David Mooney - RE: Armidale Regional Landfill, MP06_0220

PROPOSED ARMIDALE REGIONAL LANDFILL (MP 06_0220) – REVIEW OF SUBMISSIONS REPORT

ATTACHMENT 1 – OEH Review of Submission Report for Proposed Armidale Regional Landfill

TYPICAL LEACHATE POND SECTION
SCALE 1:50 (A1)

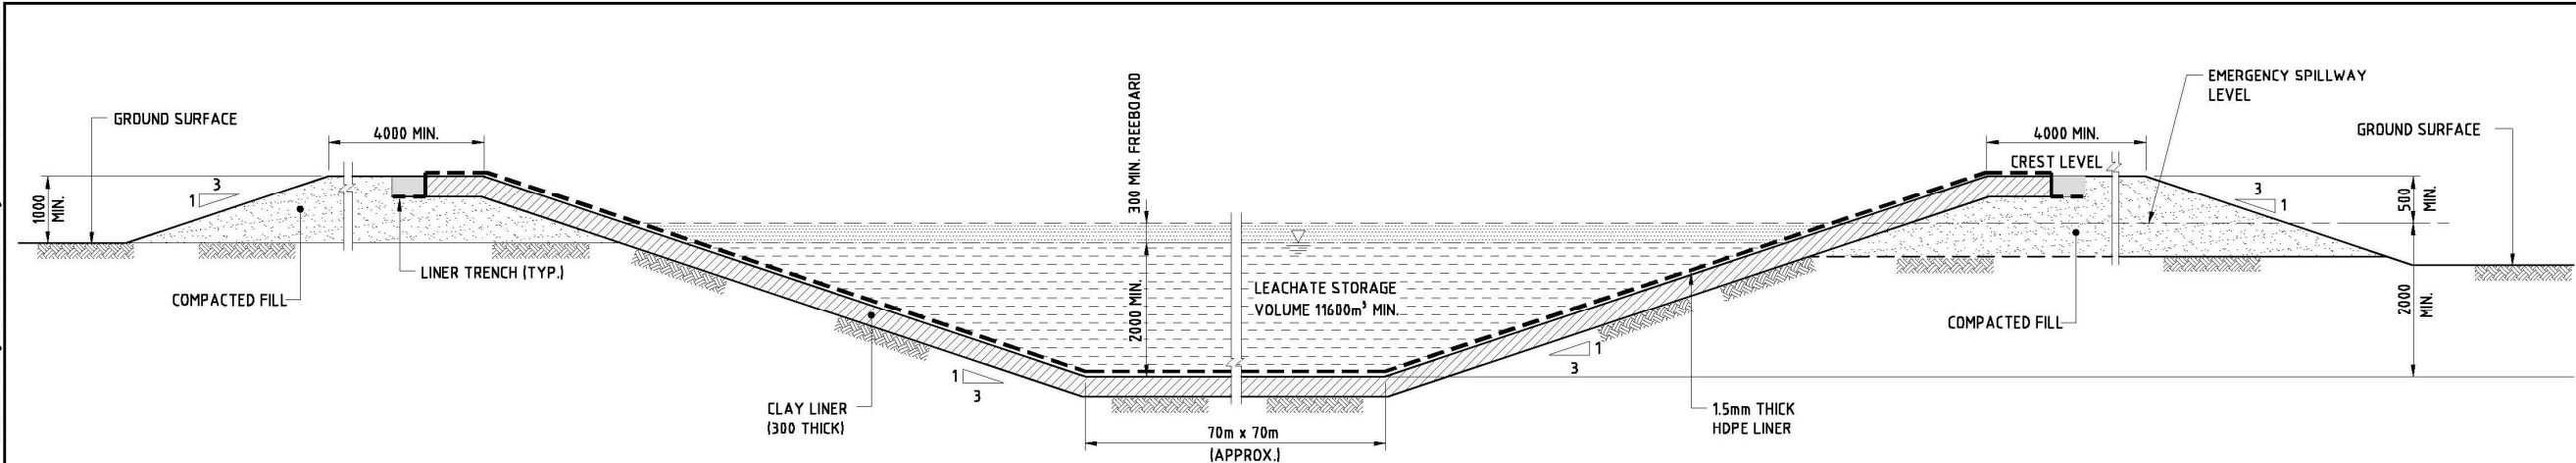
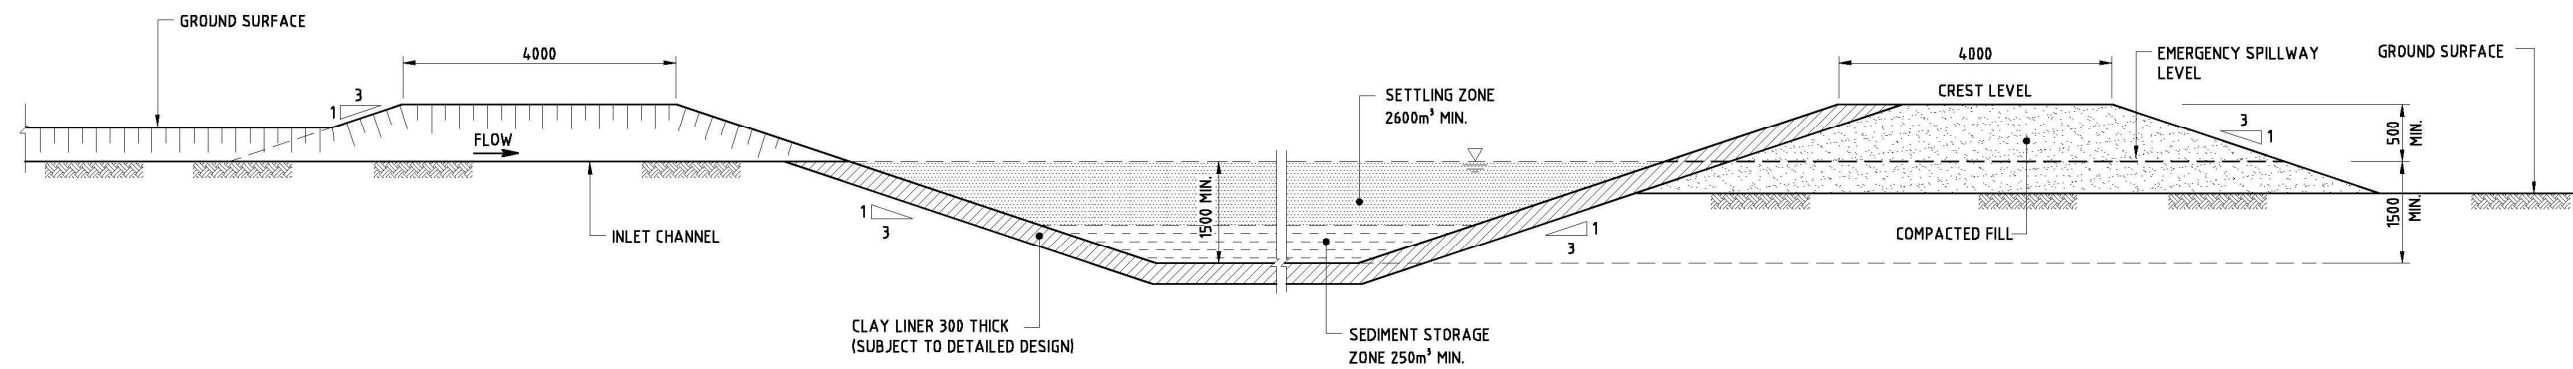
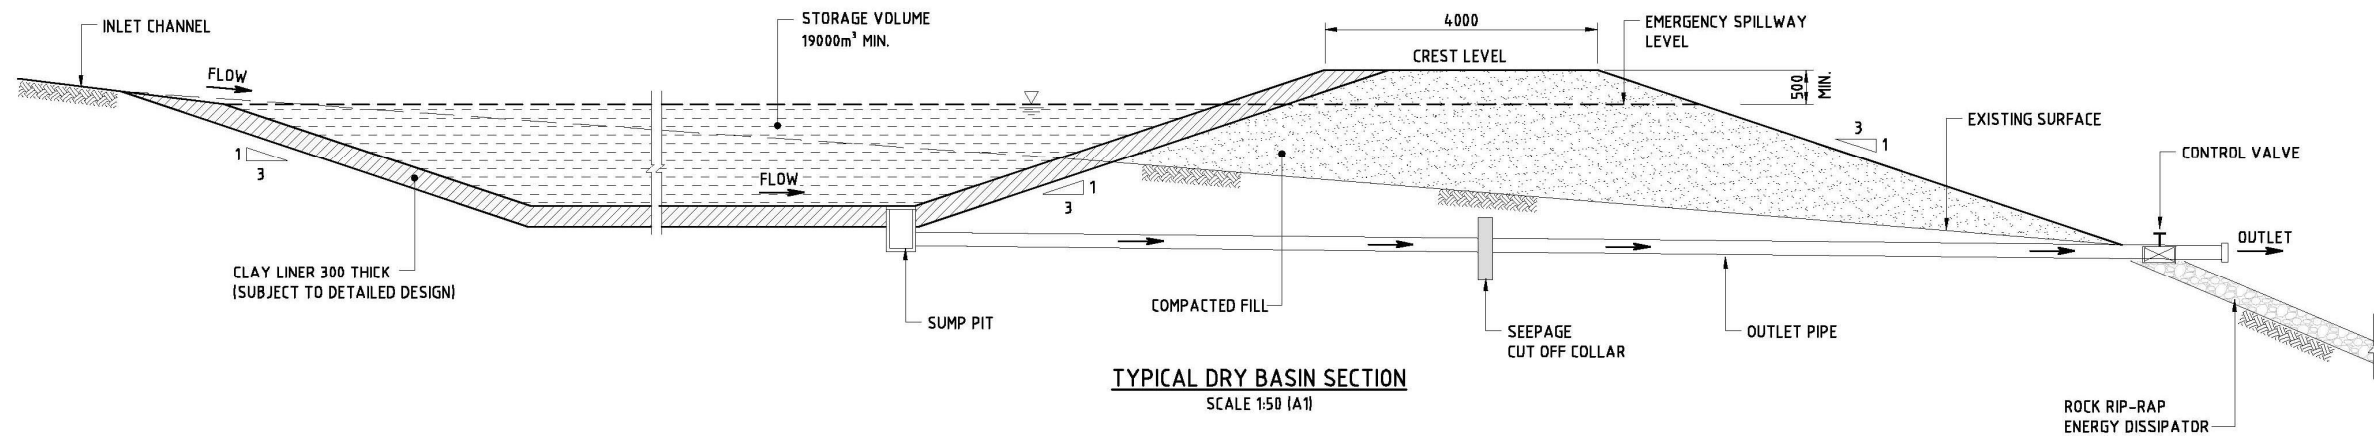
7. *The proponent should clarify the intended design for the leachate barrier system and leachate pond and provide firm commitments in the final statement of commitments for the proposed design.*

- The proponent has firstly confirmed that the leachate pond will be built to the same standard as the landfill liner but then appears to potentially contradict this by stating that “...both liners (pond and landfill) will comply with the NSW Solid Waste Benchmark Techniques, specifically Bench Mark 2: Leachate Collection systems.” Benchmark 2 does not apply to the landfill liner (Benchmark Technique 1: Leachate Barrier System does) and does not necessarily require the pond liner to be constructed to the same standard as the landfill liner (i.e. it states the pond liner should be lined “...to a similar standard to the landfill liner...”).

Given the sensitivities around this particular site, its position in the catchment and the hydraulic head that the pond liner is likely to be continually subjected to, the OEH contends that the pond liner should match or exceed the specification of the landfill liner proposed by the proponent. This issue will need to be resolved at the final detailed design stage.

- The manner in which the proponent has addressed the OEH's concerns with respect to the potential for deterioration of any HDPE liner as a result of UV radiation is also unclear and potentially contradicts with earlier statements. For example the statement “If a HDPE liner is designed for the leachate pond...” appears contradictory to the initial statement made by the proponent that indicated the “...leachate pond would be built to the same standard as the landfill liner...”.

The proponent's response offers two design alternatives (i.e. using UV stable liner products or a sacrificial protection cover layer) to address the OEHs concerns with regard to the effect of UV radiation on the liner. The proponent also indicates that if the “...liner of the leachate pond has deteriorated then it will be replaced as part of the site's LEMP.” While this would be necessary and expected, the proponent should not allow for the planned deterioration and replacement/repair of the liner as part of any standard maintenance or life expectancy of the liner through uncontrolled UV exposure and build this short term life into the LEMP. The LEMP should still incorporate any necessary UV exposure controls are maintained, incorporate liner integrity monitoring and replacement/repair procedures to ensure unpredicted liner failures are dealt with in a timely and appropriate manner.
